RE: Addressing Geologic Hazard and Soils Report for Vollmer RV Storage, Lot A, McClintock Station

The purpose of this letter is to address the need for a geologic hazard and soils report to support the proposed development of Lot A, McClintock Station known as Vollmer RV Storage.

**POND CROSS SECTION A PROFILE  
STA 1+00.00 TO 2+35.14**

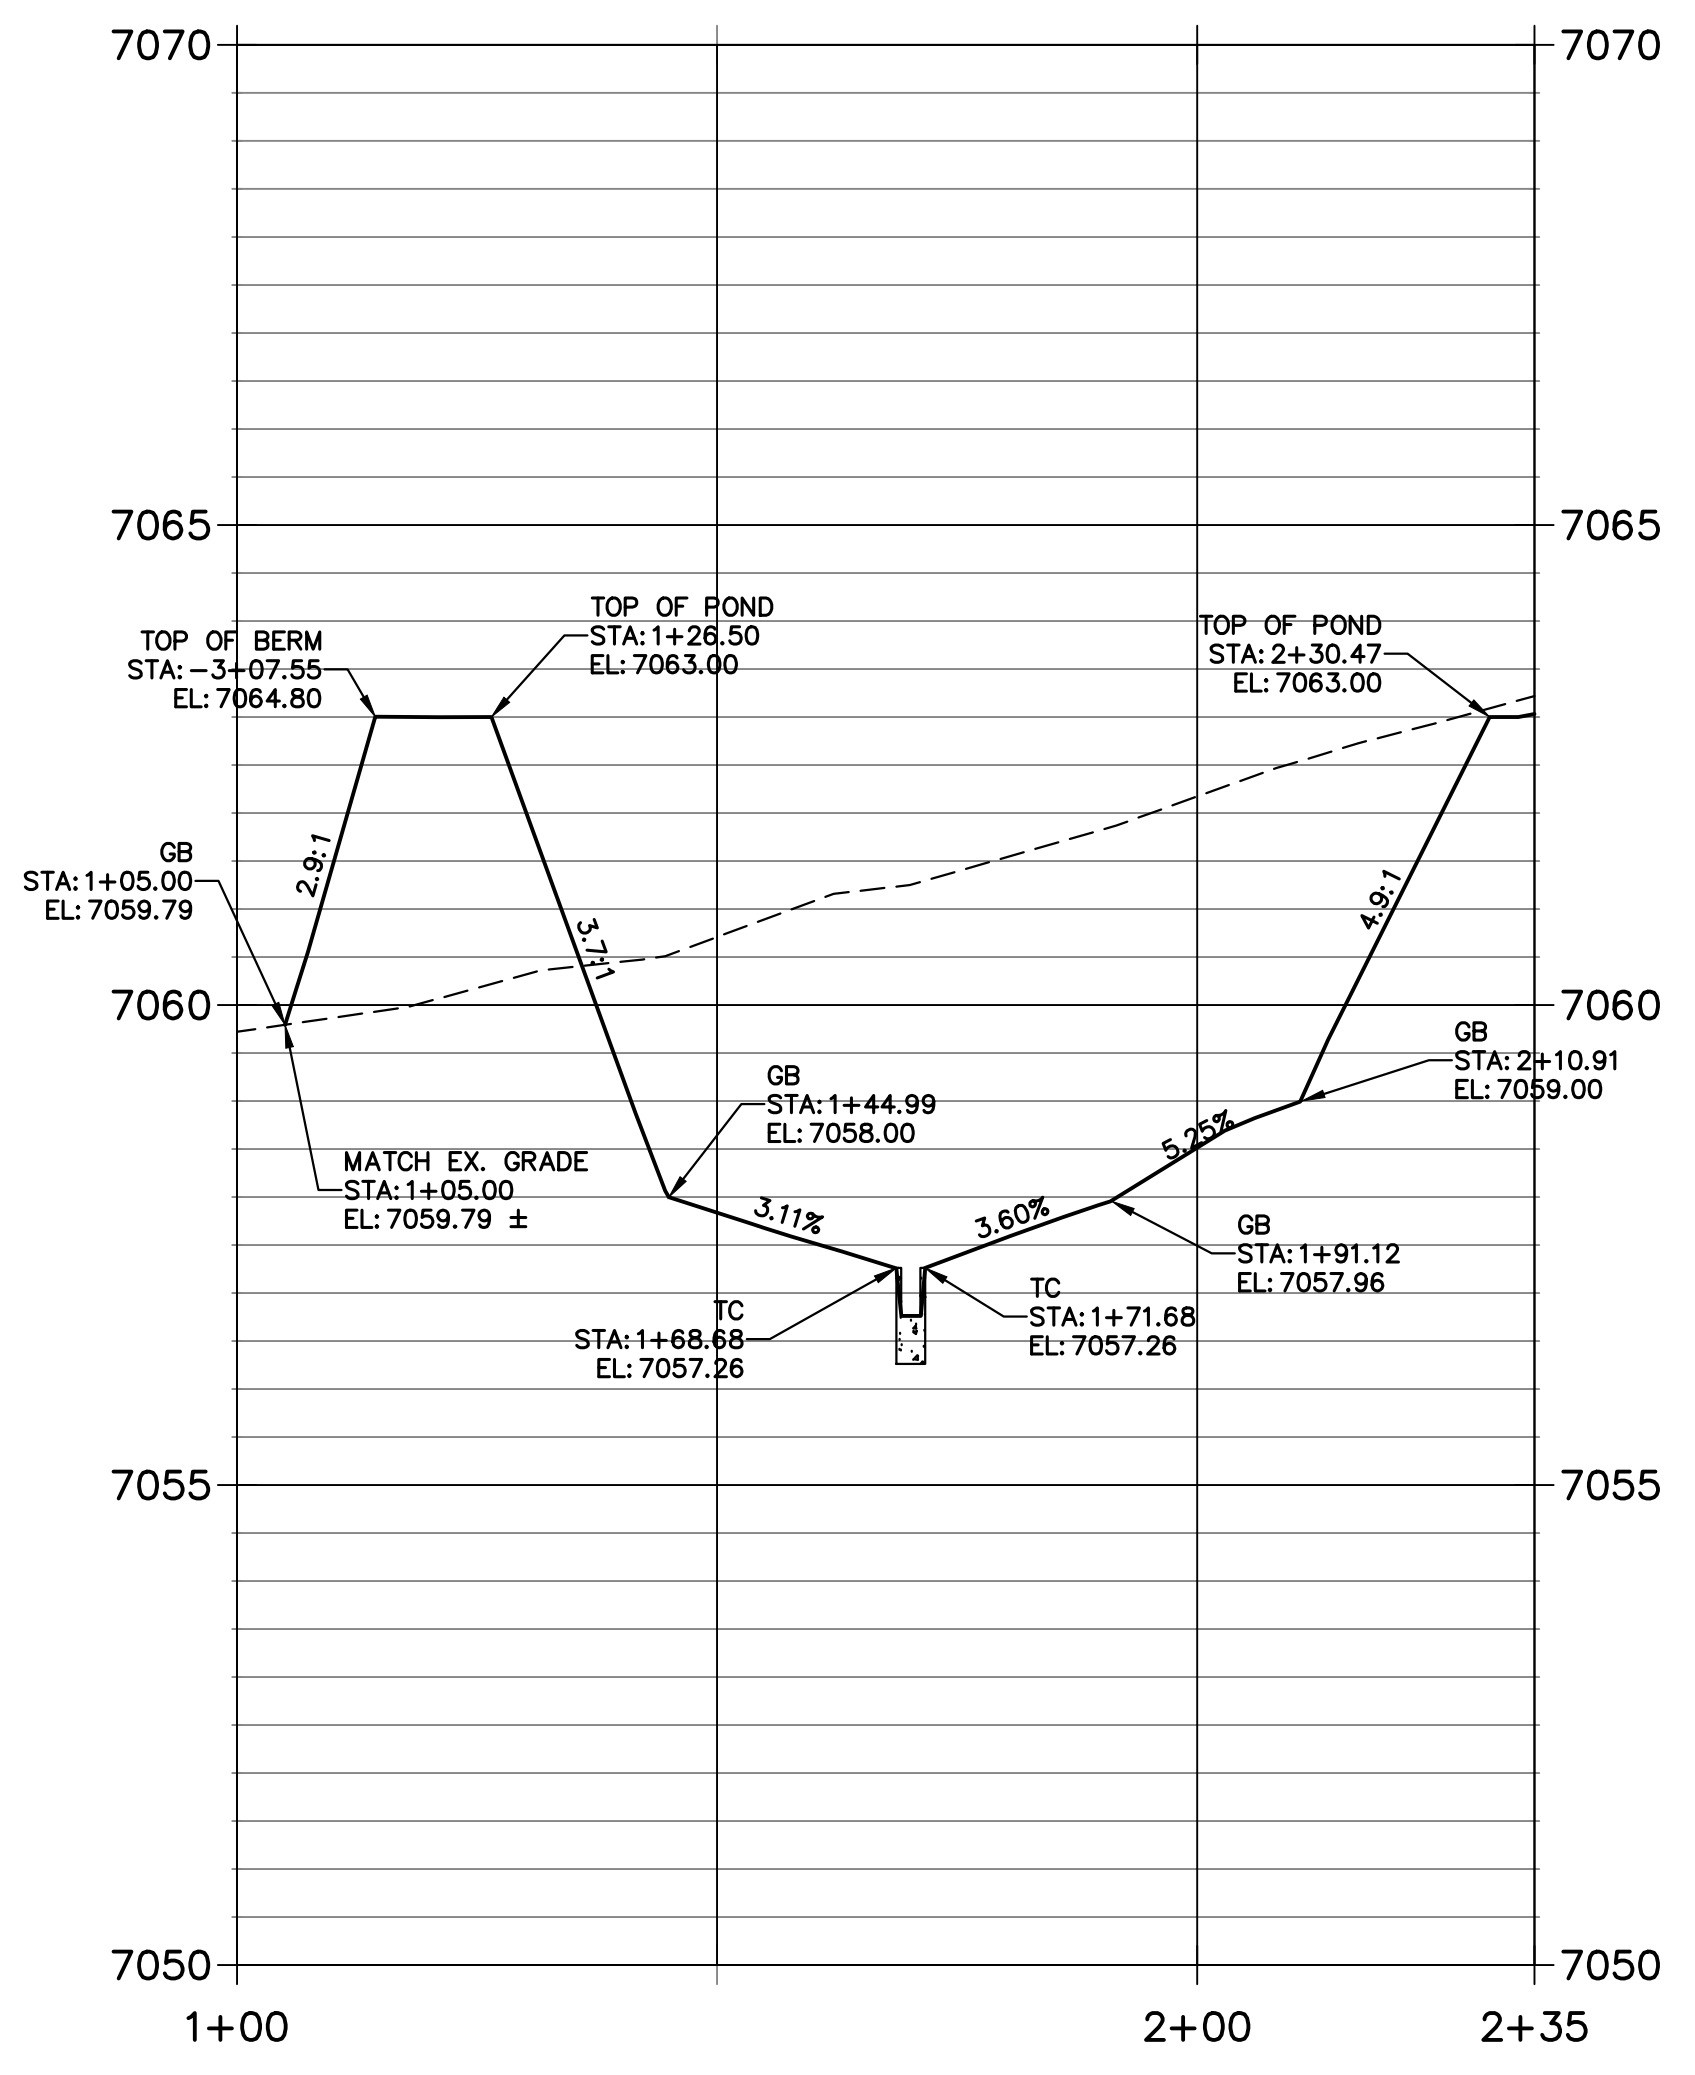
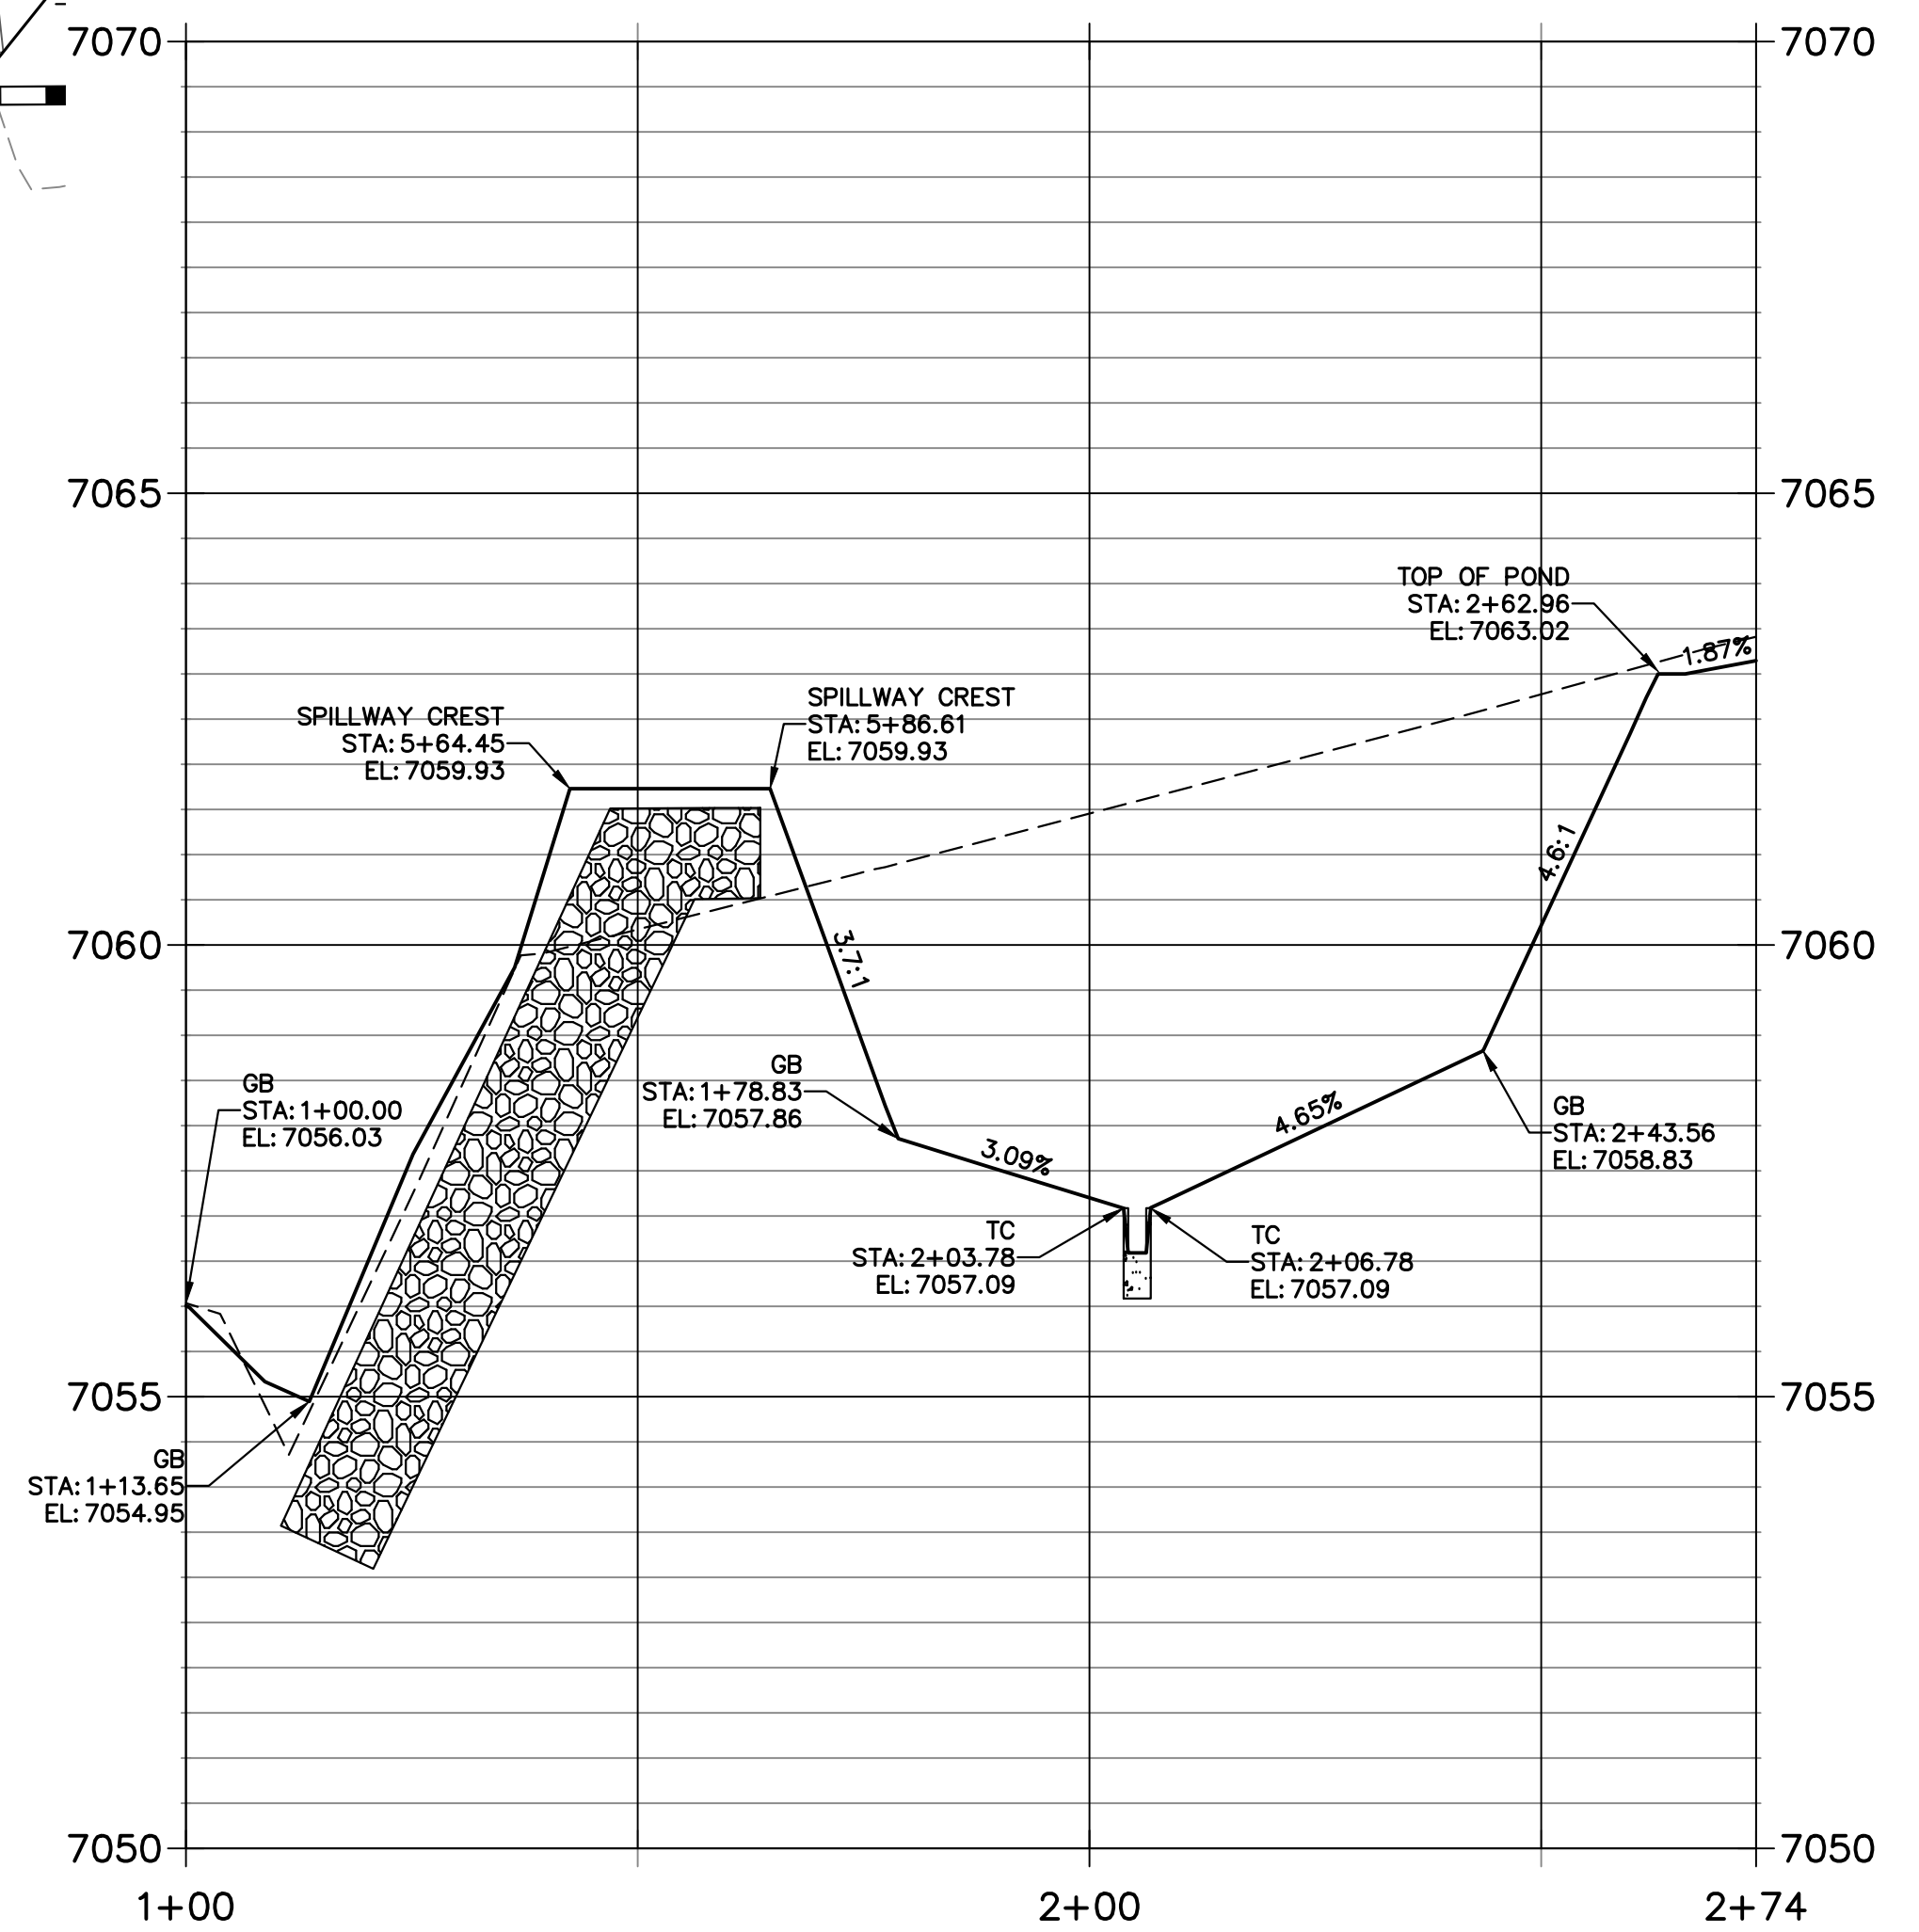
JR Engineering recommends that a qualified Geotechnical representative be on-site to observe the proposed embankment construction, and to specifically assess the suitability of the on-site soils for use in the embankment construction. **Need to know if on-site material is suitable or material will need to be imported. What will the compaction requirements be, thickness of lifts, overall height limits, etc.**
